From: Charlotte Burrows on behalf of Planning.Responses
Sent: 14 December 2011 08:42
To: Amanda Scholes
Subject: FW: AW/262/11 - OBJECTION
Attachments: 9Kingsway--DrivewaySA-AW-262-11--Dec-1.doc

AW/262/2011-2- Application for New Driveway and Hardstanding

FURTHER OBJECTION – AW/262/11 –
Application for a New Driveway and Hardstanding
at No 9 Kingsway, ON THE CRAIGWEIL HOUSE CONSERVATION AREA

GROUND FLOOR PLAN

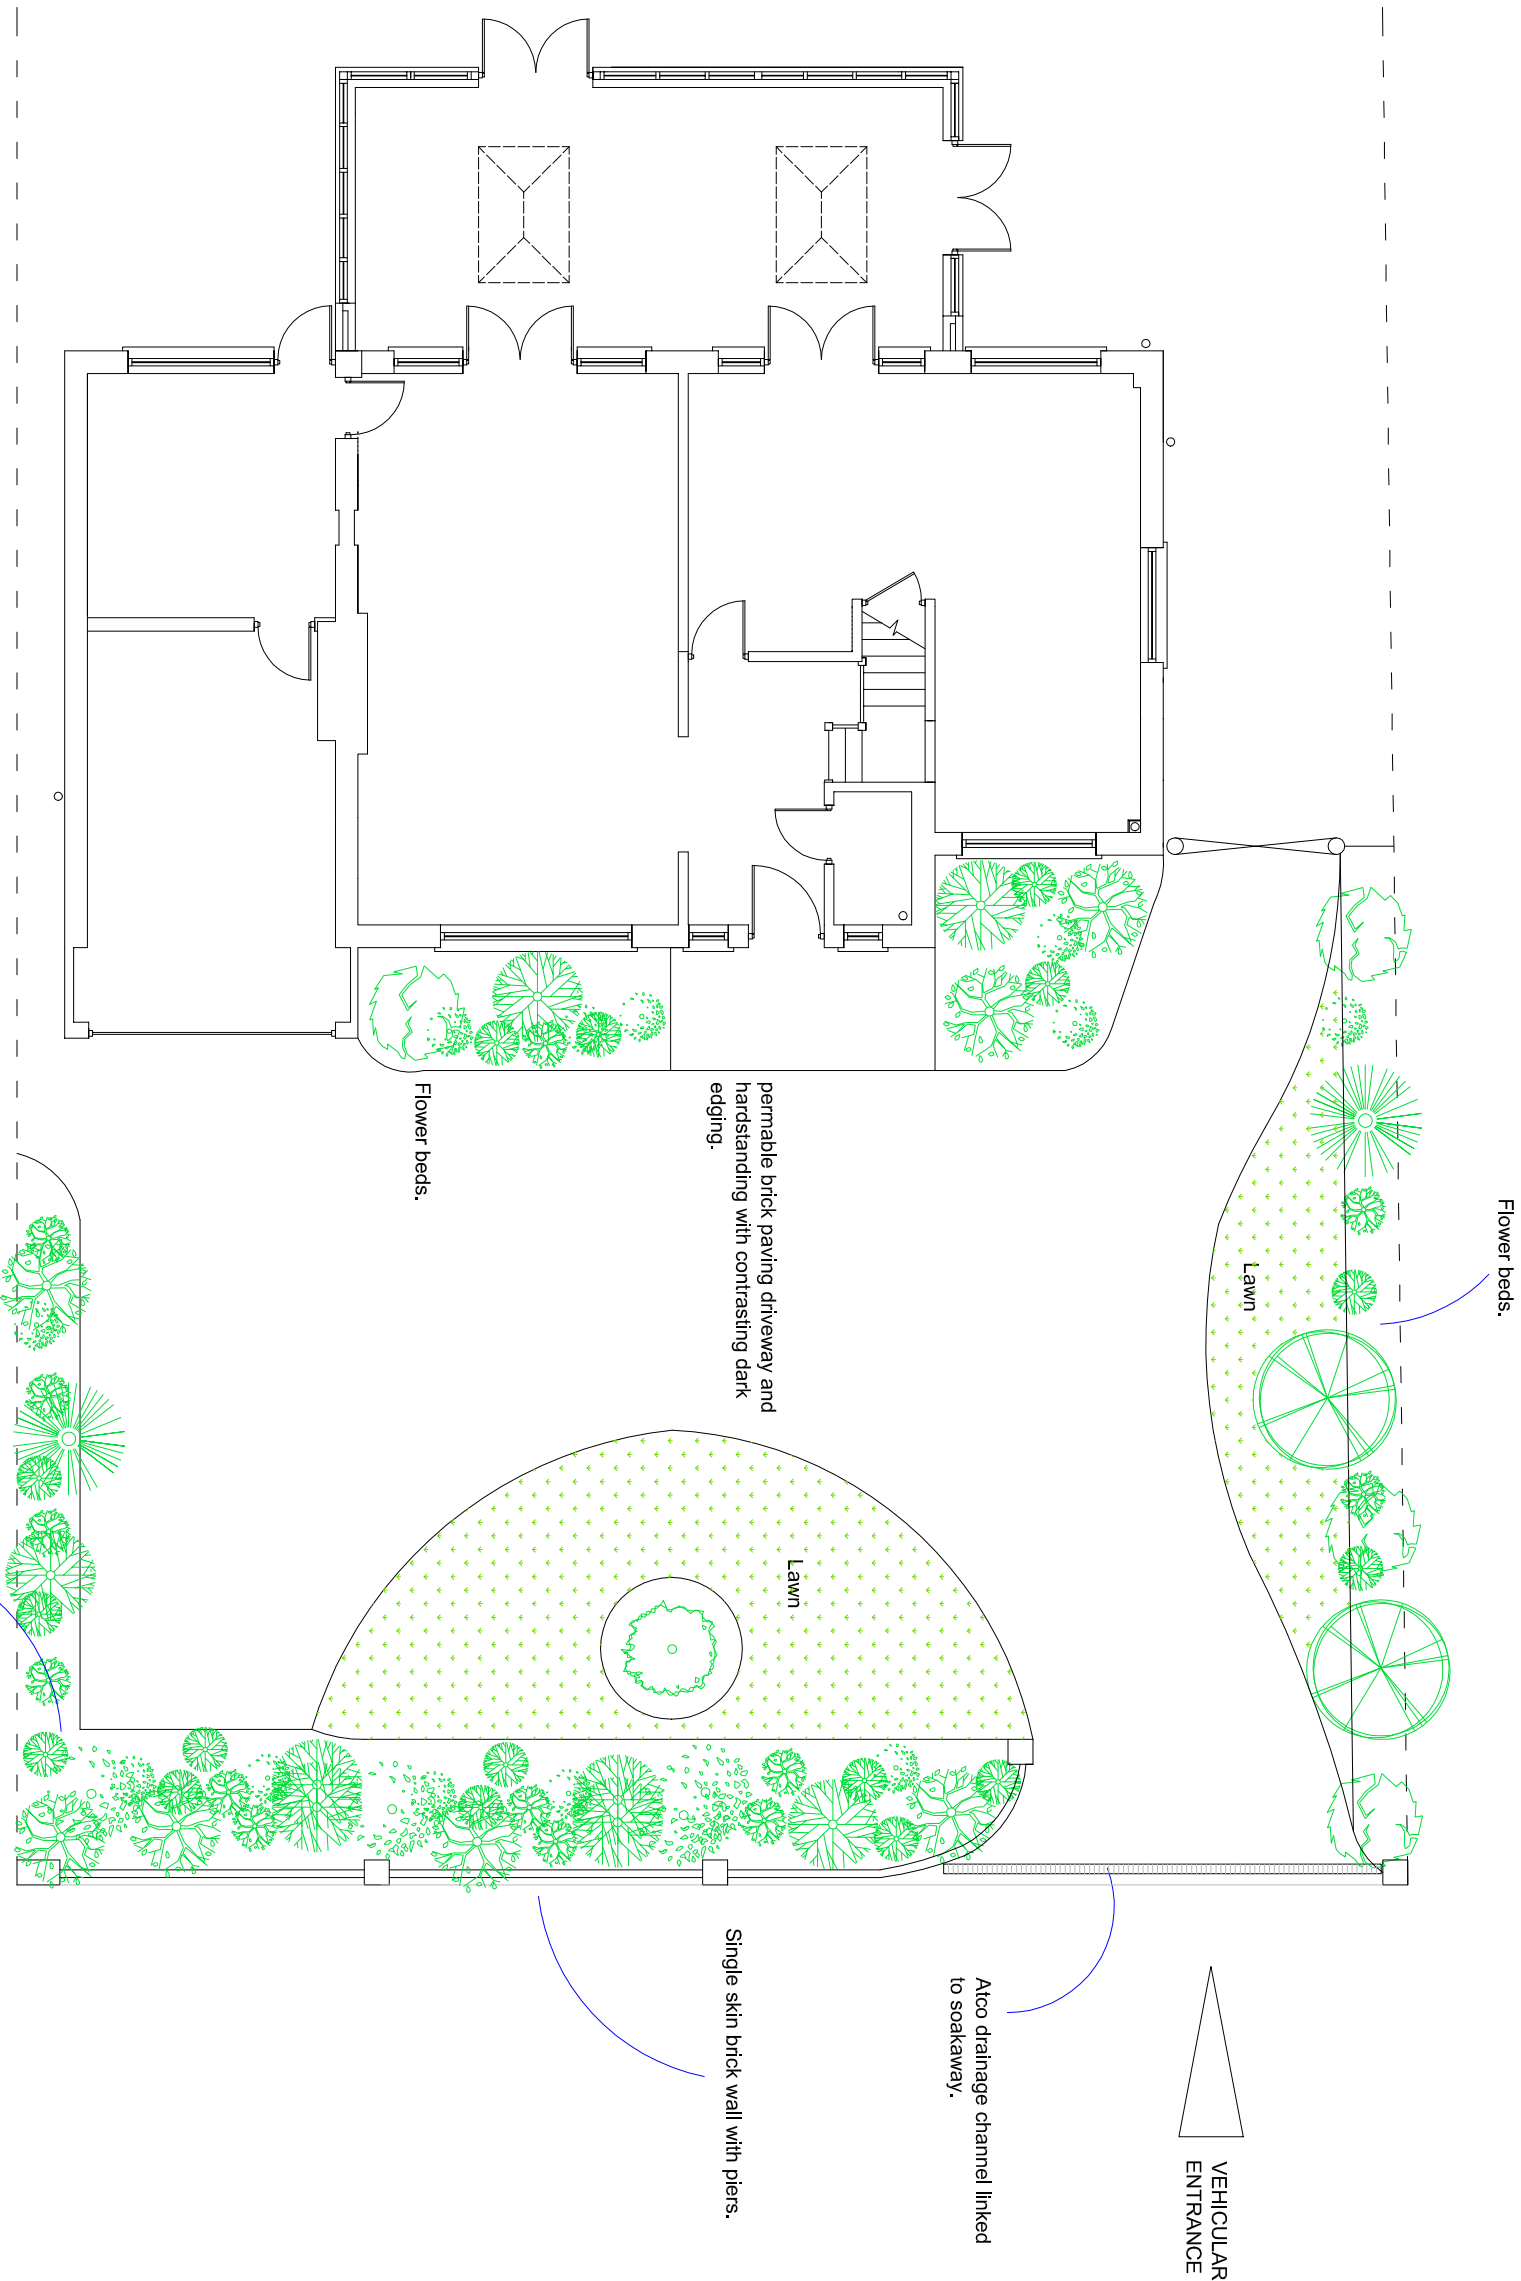
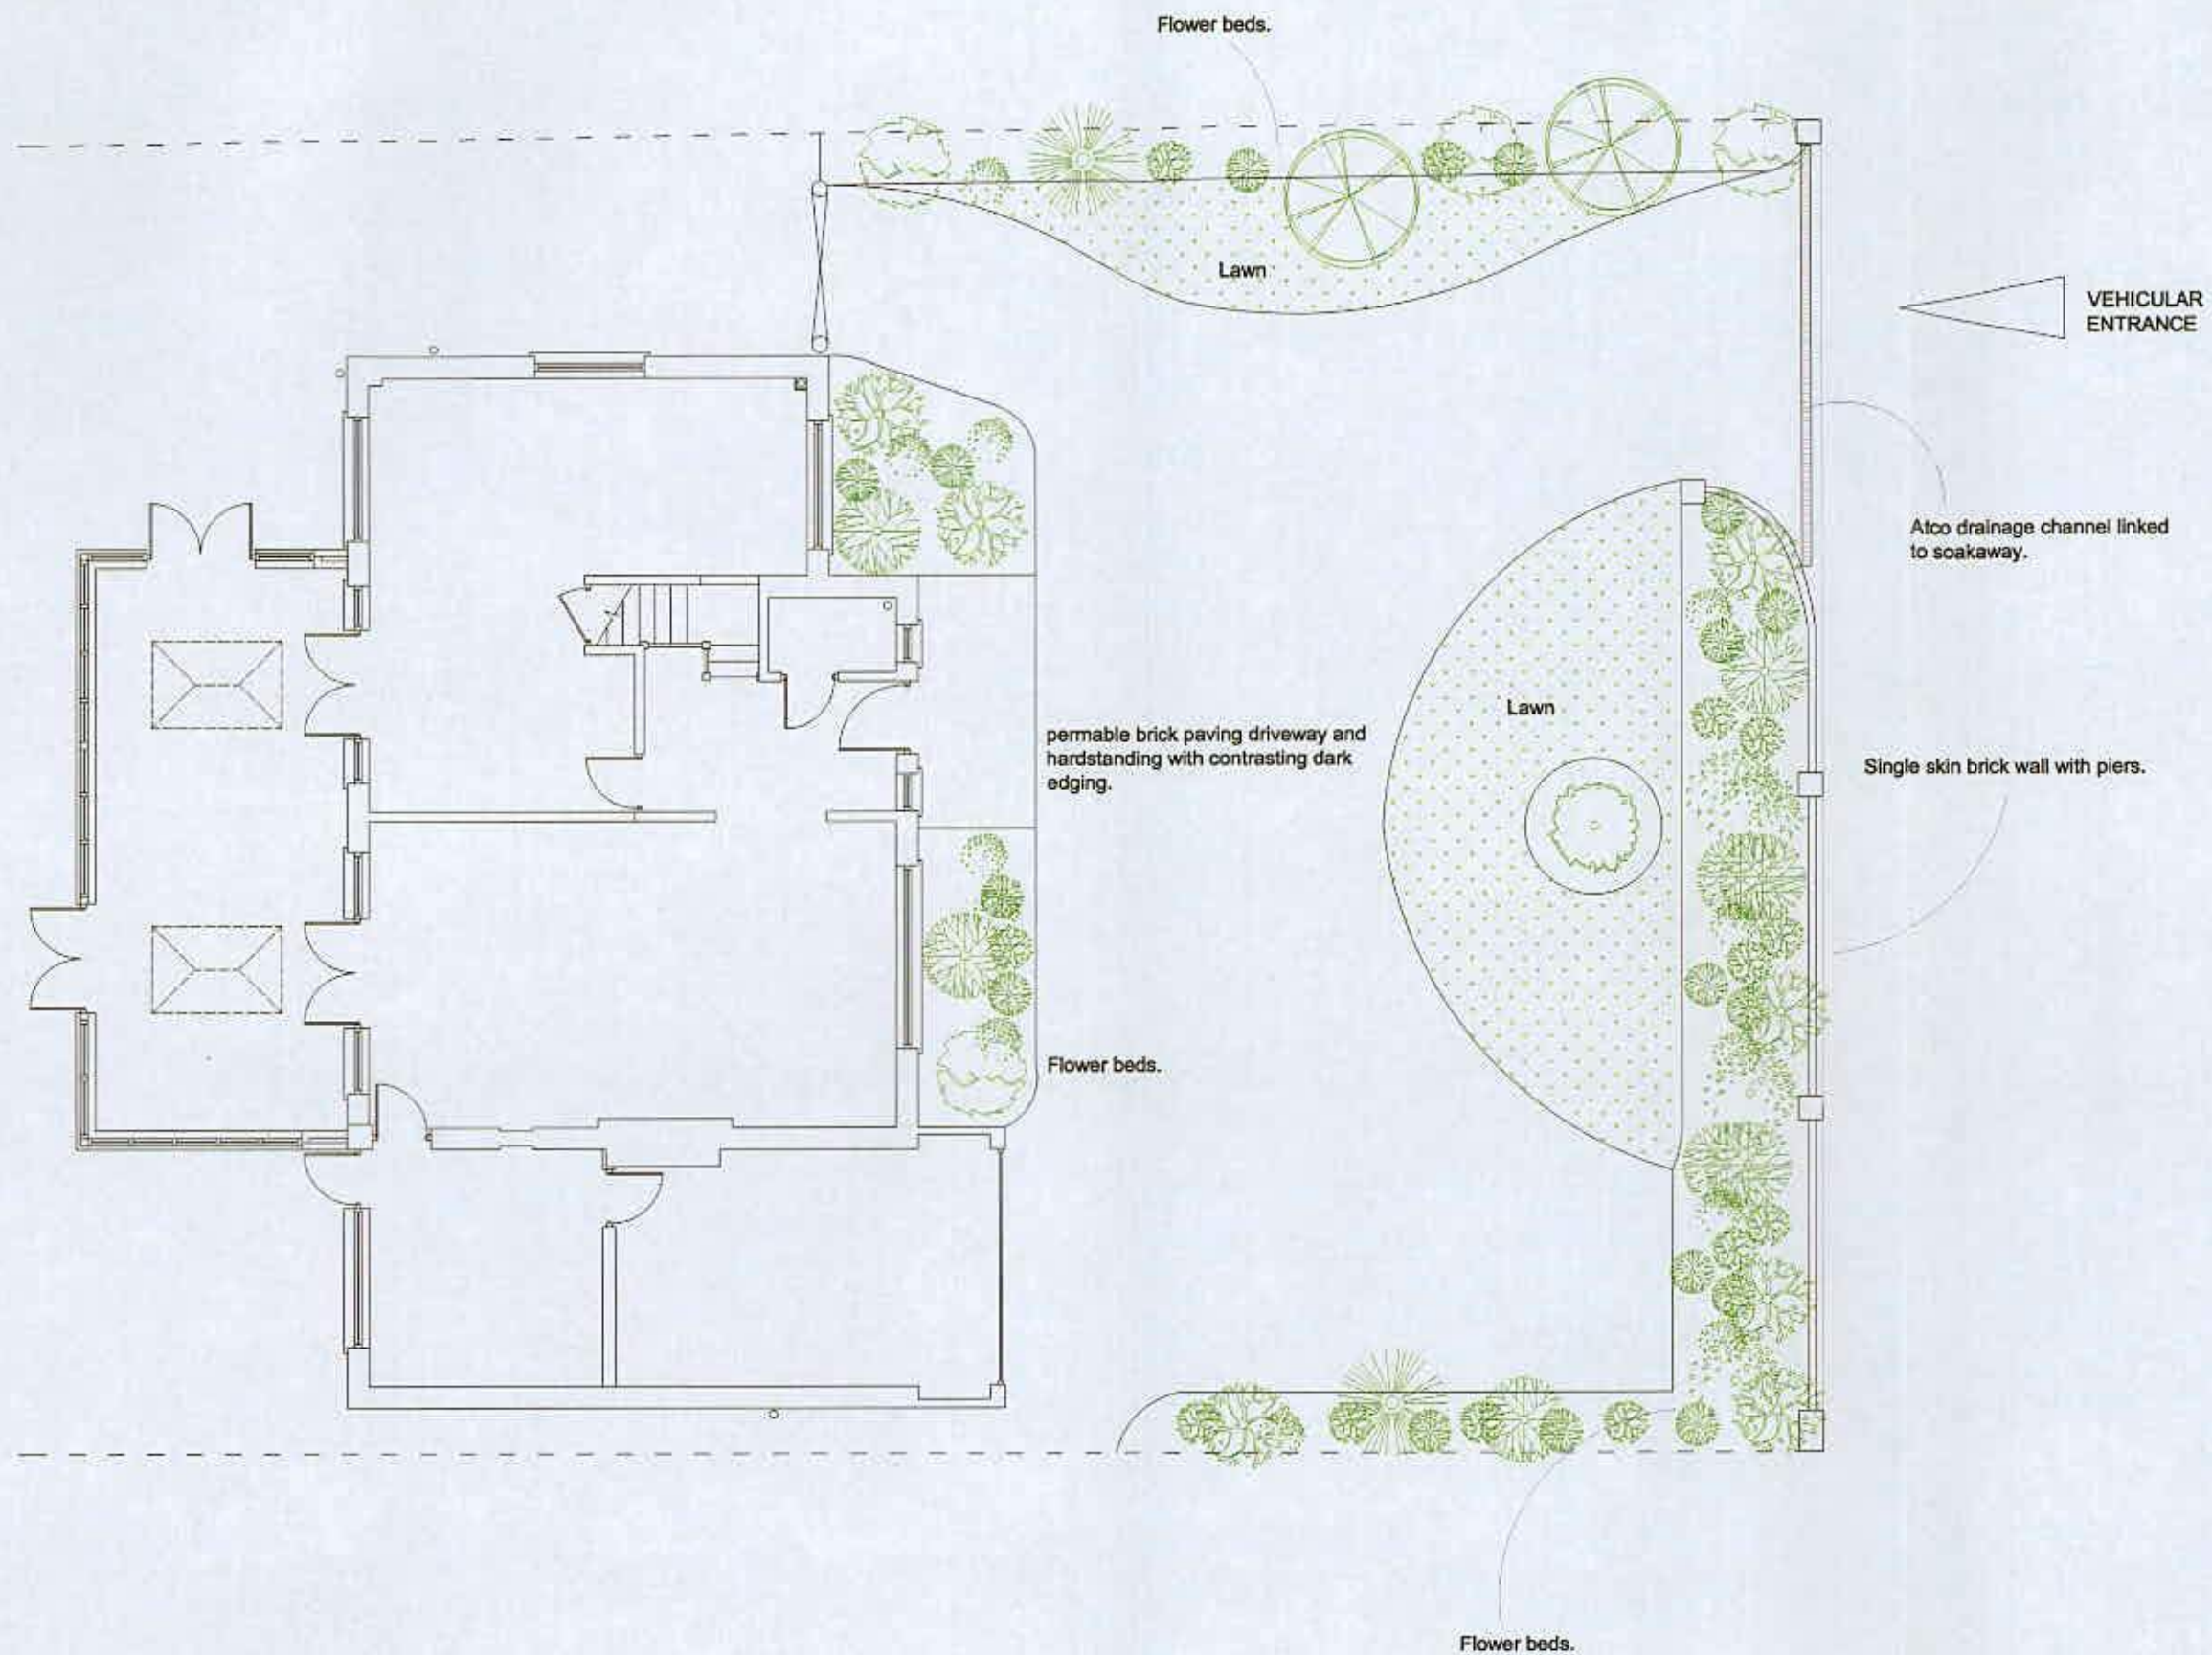
We remain very concerned that by allowing the percentage of hard standing proposed in this new Application, there remains the considerable risk that the low wall to the front of the property may/will be removed under Permitted Development Rights, as the Article 4 restrictions in place for the CA are not applicable according to the CA Officer. Such removal would provide an 'in and out' carriageway to the property, thereby destroying the principle of retaining the open character of the frontages to properties in the area. The precedent would also be set **for many other properties** to be given the same treatment, thus **further undermining** one of the principal characteristics of the area.

We therefore request **that in the resolution to this Application AW/262/11**, should you be minded to allow it, there would be attached a **Condition that- Permitted Development Rights be withdrawn for the removal/demolition in full or in part, of the front wall to the property.**

This Application is the simplest of amendments to the **previously refused AW/155/11** without addressing the main objection of ADC's Members, namely, **the excessive proportion** of hard standing to the front 'garden area' of the property. **It has simply added a minimal amount of bordering** for plants, a few inches here and there, but retaining a very high percentage of hard landscaping, **right across the frontage of the property.**

As was pointed out in the previous applications, it was the placement of the present garage to the west of the house that has exacerbated this position. When 'planning' this present application requirement, instead of creating a **replacement entrance** for the driveway to the west of the house, the Applicant and his 'professional' advisors used the existing entrance to the east, requiring vehicles needing to be garaged to be driven across the frontage of the house and further, creating a turning point outward, towards the sealed west side of the curtilage. This plan defies the principles of establishing the Article 4 Directions which seek to restrict the amount of hardstanding, thus despoiling the 'character and appearance' of properties and their surroundings.
